**Prior Approval Application under Part 3, Class P of
The Town and Country (General Permitted
Development) (England) Order 2015**

Address 44 WATERLOO ROAD UXBRIDGE

Development: Change of use from Use Class B8 (Storage or Distribution Centre) to Use Class C3 (dwellinghouse) for 6 x 1 bed flats (Prior Approval).

LBH Ref Nos: 1654/APP/2017/2801

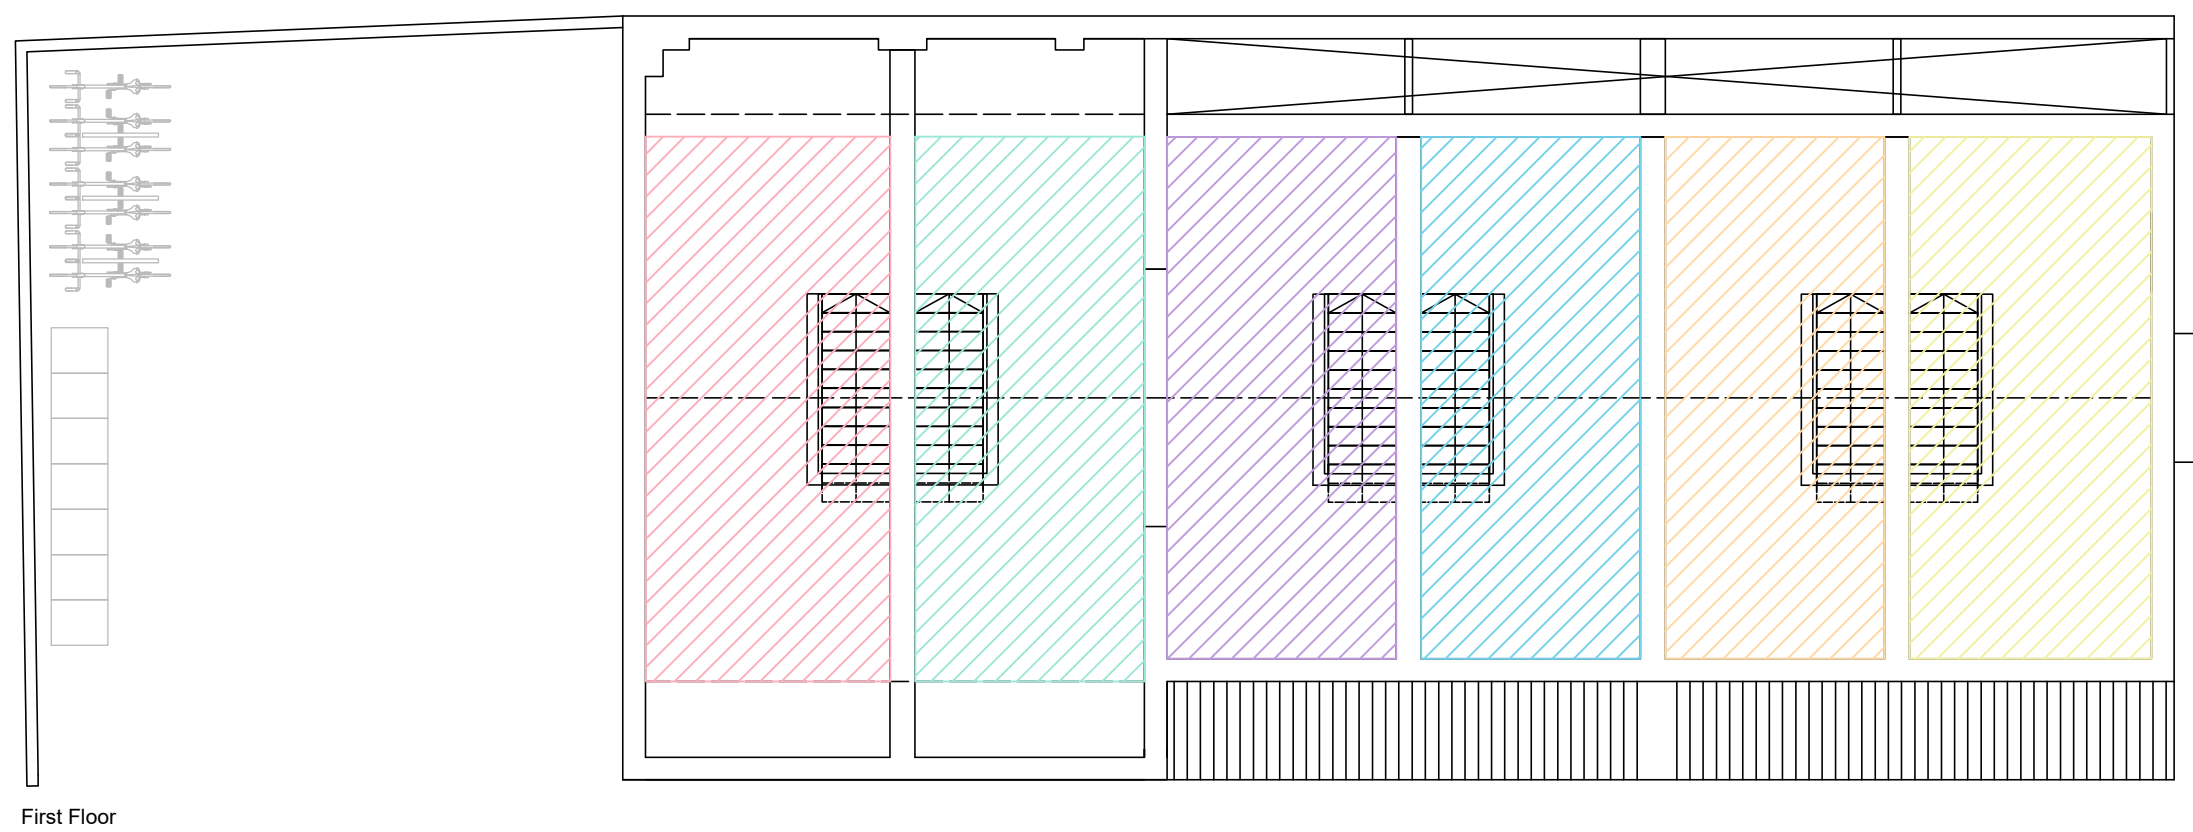
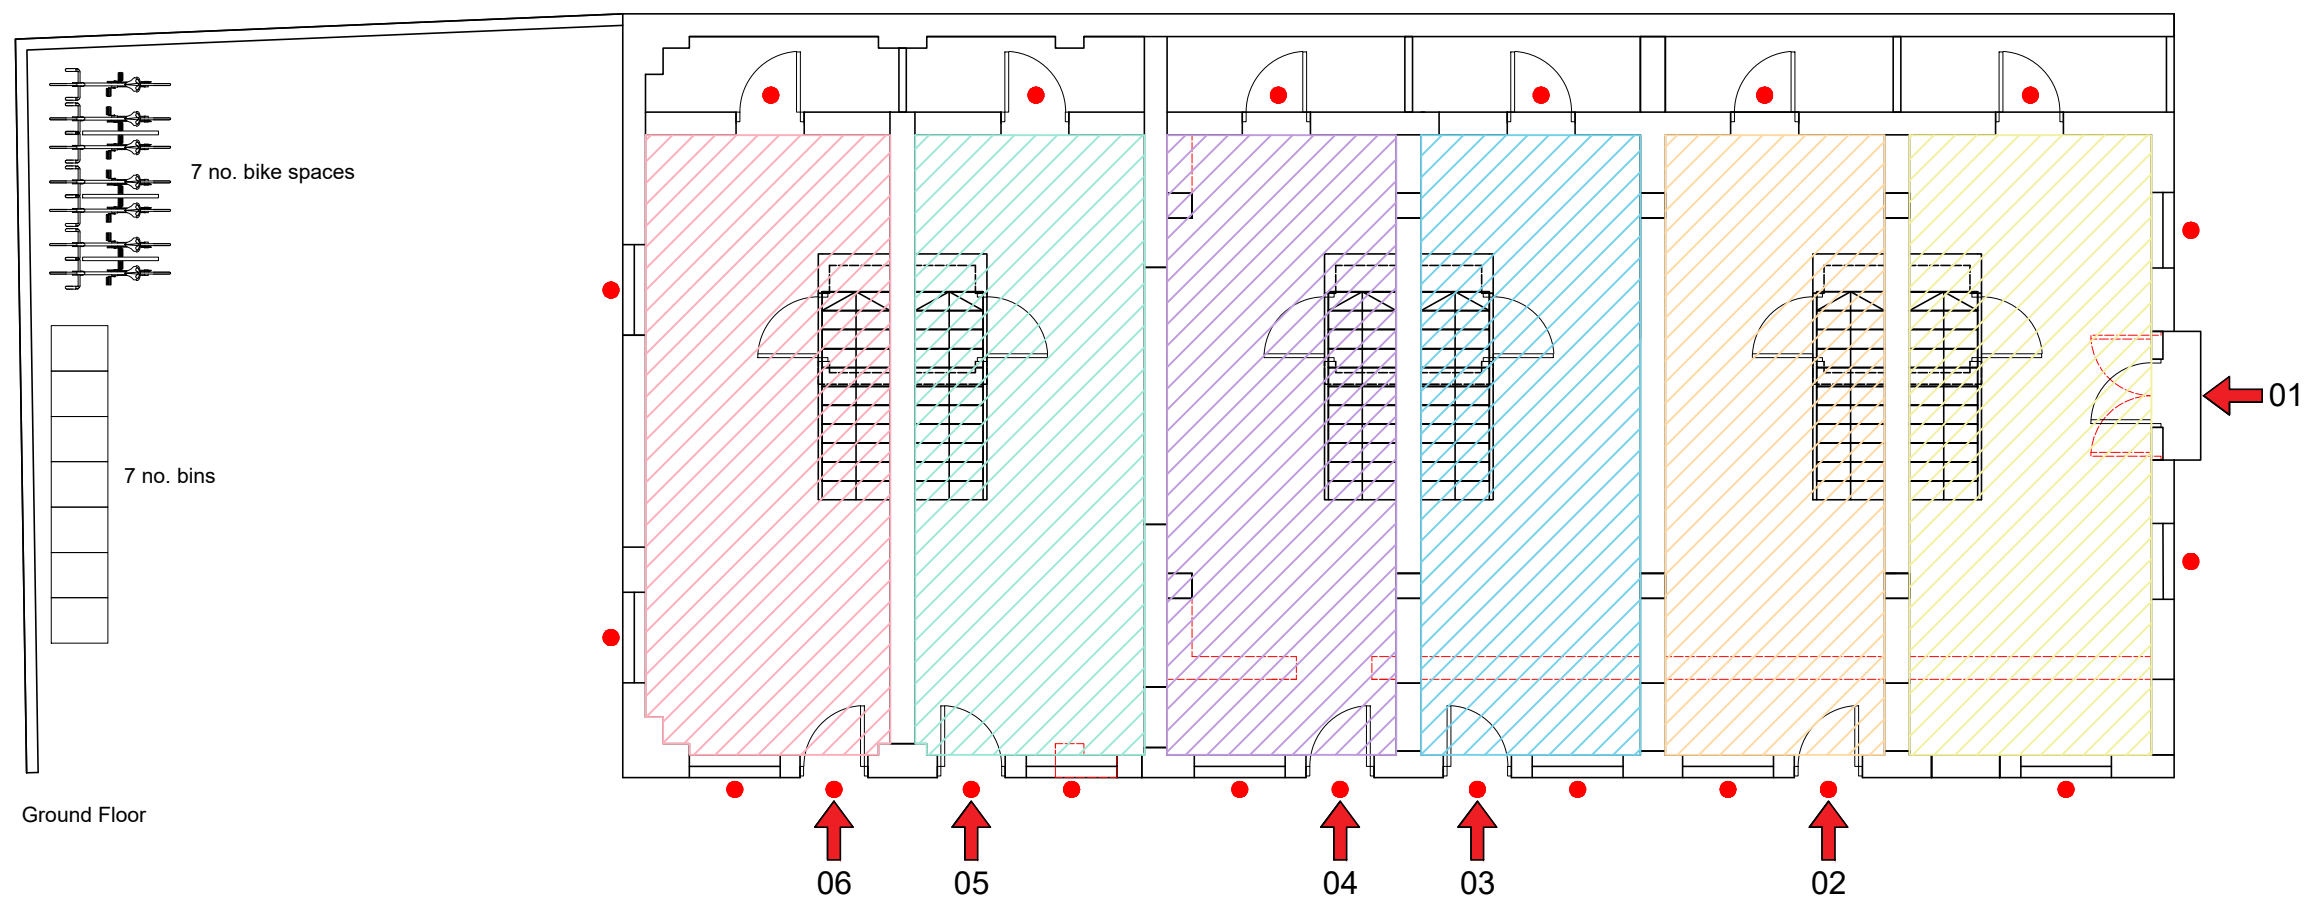
Notwithstanding the hereby approved drawing ref: JM043 - BPS - GA - 900, prior to occupation of the development, the following shall be provided on site:

1. 3 car parking spaces with markings
2. Secure and covered cycle parking spaces to be provided for 7 bicycles as a minimum

Notwithstanding the hereby approved drawing ref: JM043 - BPS - GA - 900, prior to occupation of the development, details of refuse and recycling storage shall be submitted to and approved in writing by the Local Planning Authority. Thereafter, the storage shall be carried out as agreed and remain in perpetuity, unless otherwise agreed in writing by

The proposed development would provide 6 new residential units; three parking spaces would be provided within the rear yard of the site. It is noted that during the public consultation no objections were received in regards to parking.

The proposed development has been amended to include three on-site parking spaces which is considered acceptable.
